SCOPING OPINION:

Proposed Dean Moor Solar Farm

Case Reference: EN010155

14 September 2023

Drawing file: published-documents / EN010155-000076-6.2 ES Figure 6.3 Zone of Theoretical Visibility.pdf

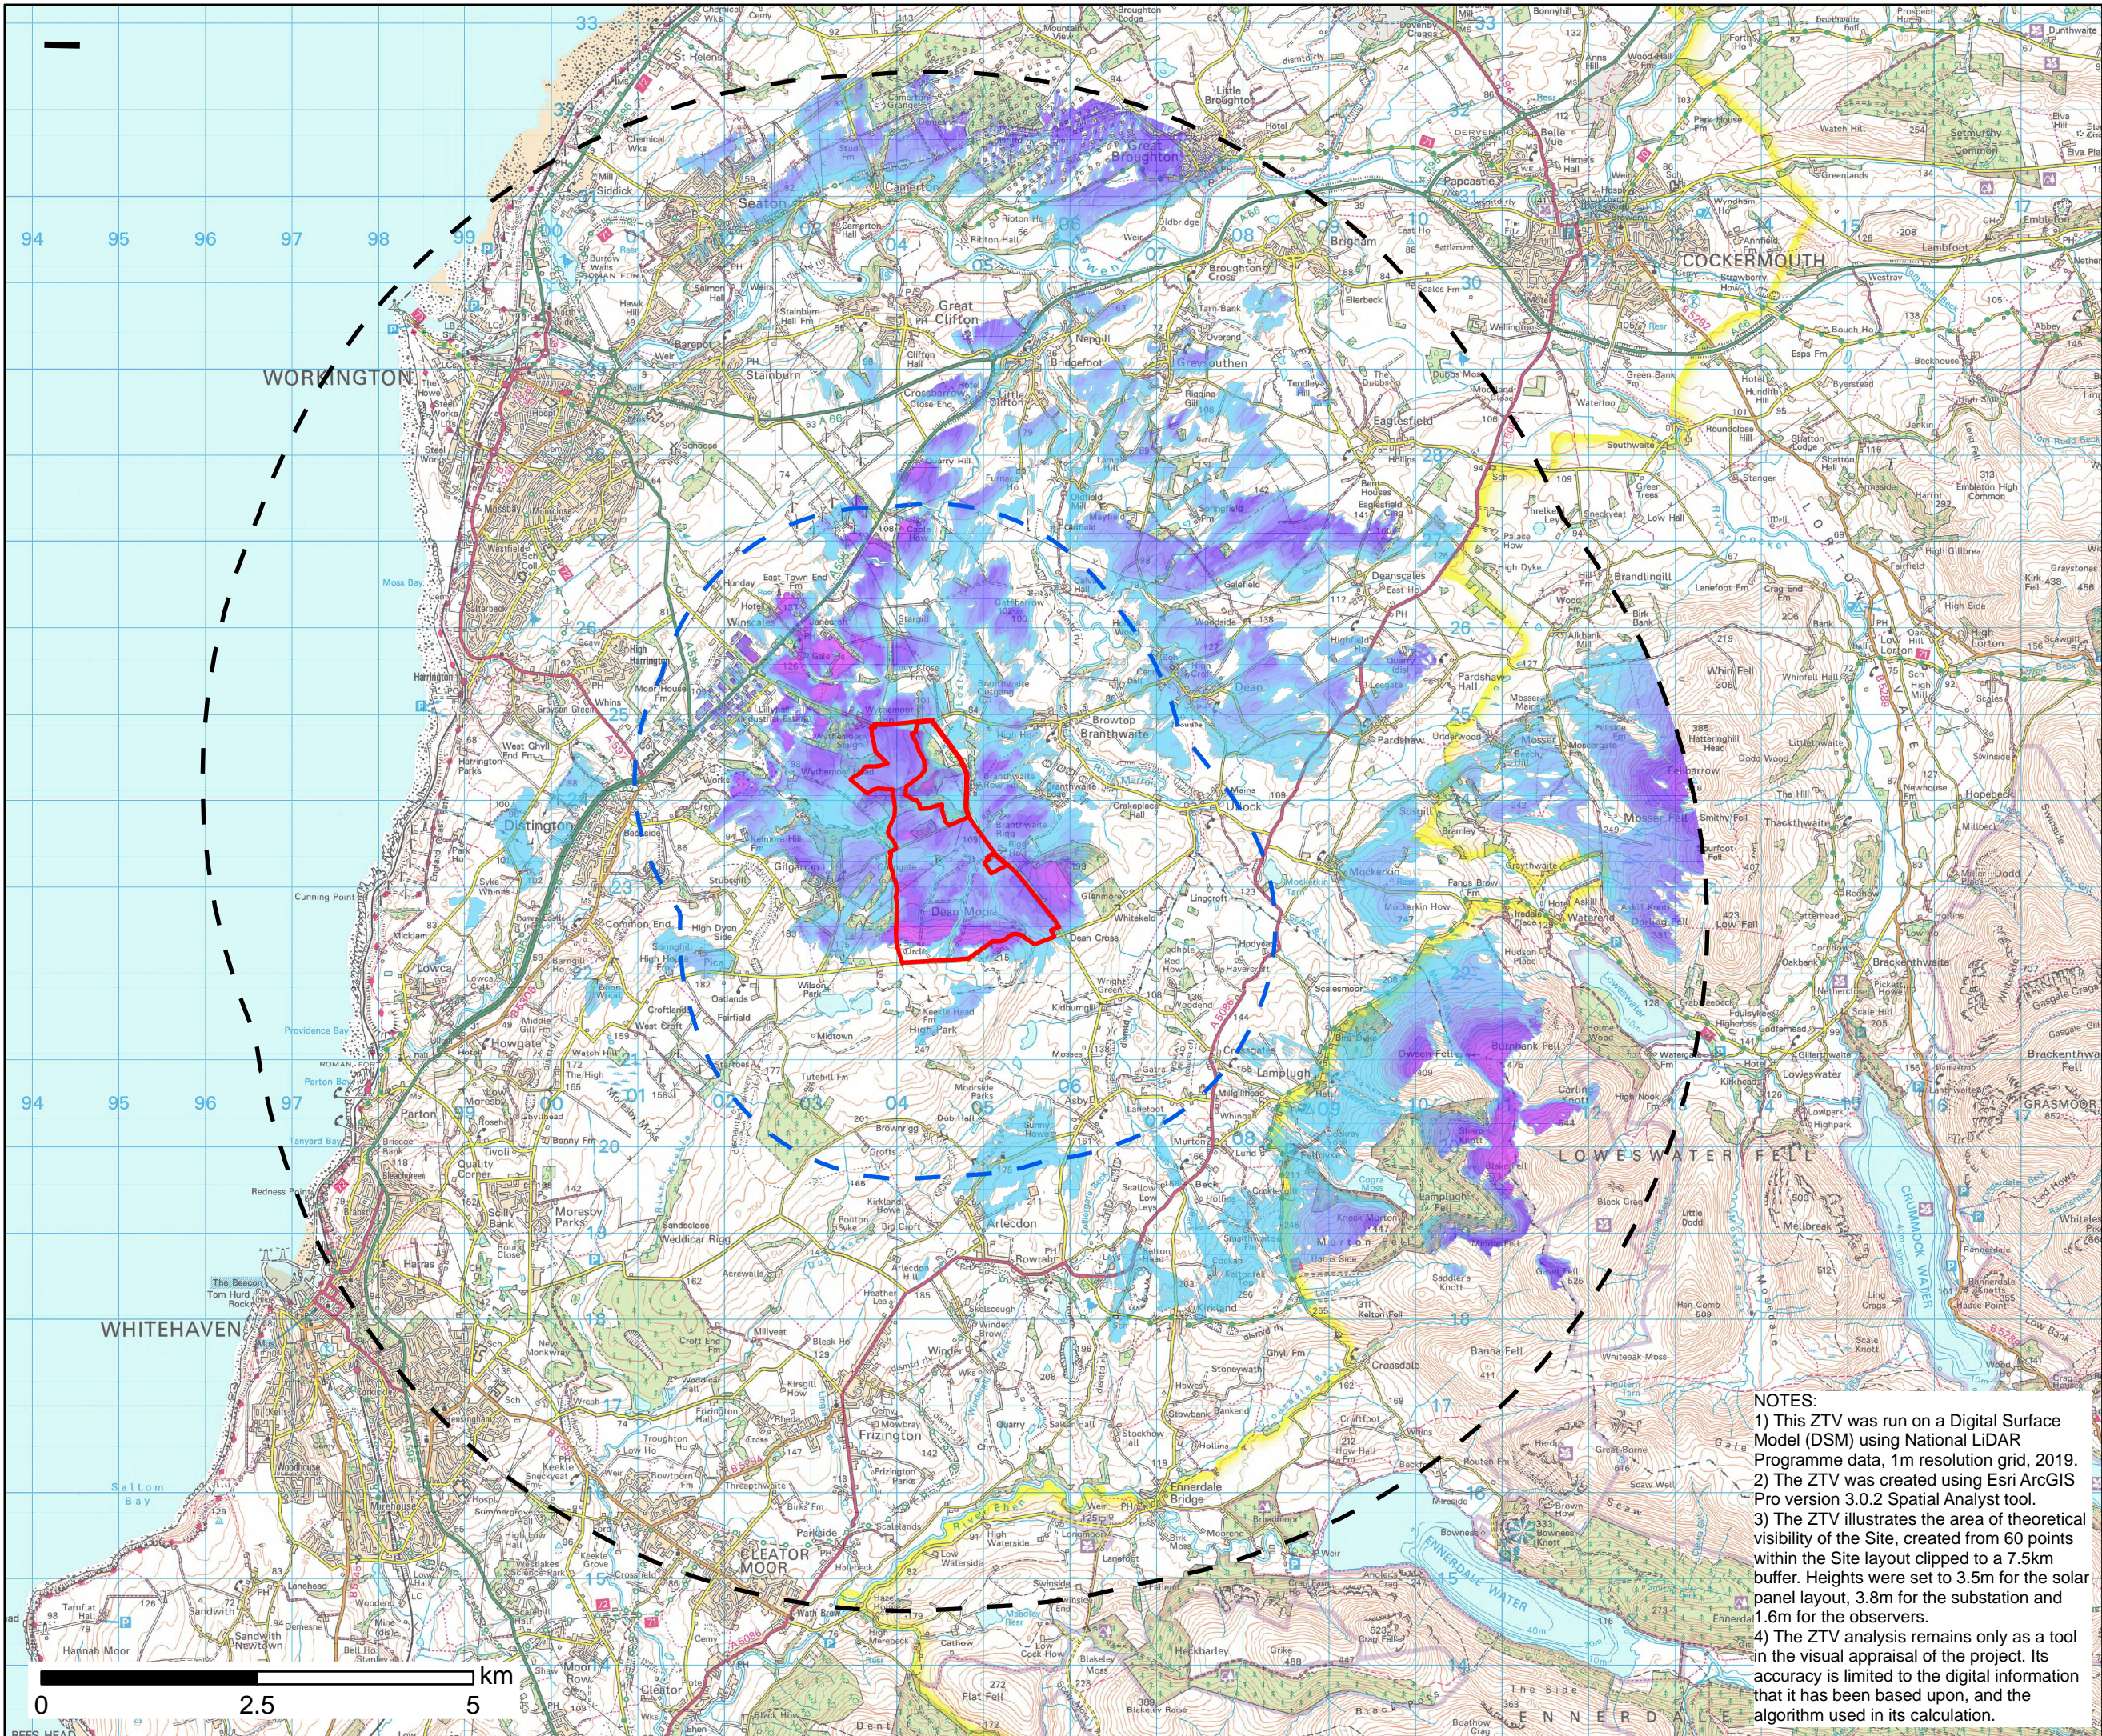
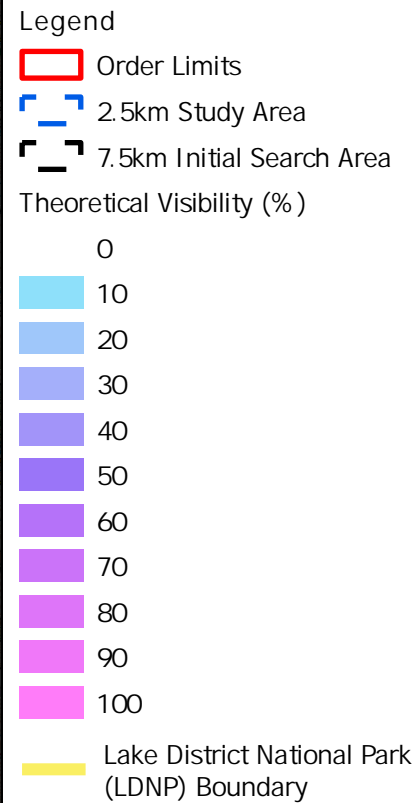
ID	Ref	Description	Inspectorate's comments
3.2.6	Paragraph, 6.3.1, 6.4.7, 6.9.5, Table 6.1, 6.2 and Figure 6.3	Zone of Theoretical Visibility (ZTV)	The preliminary ZTV and its analysis should be justified in the ES, consulted on and agreed with relevant consultation bodies.
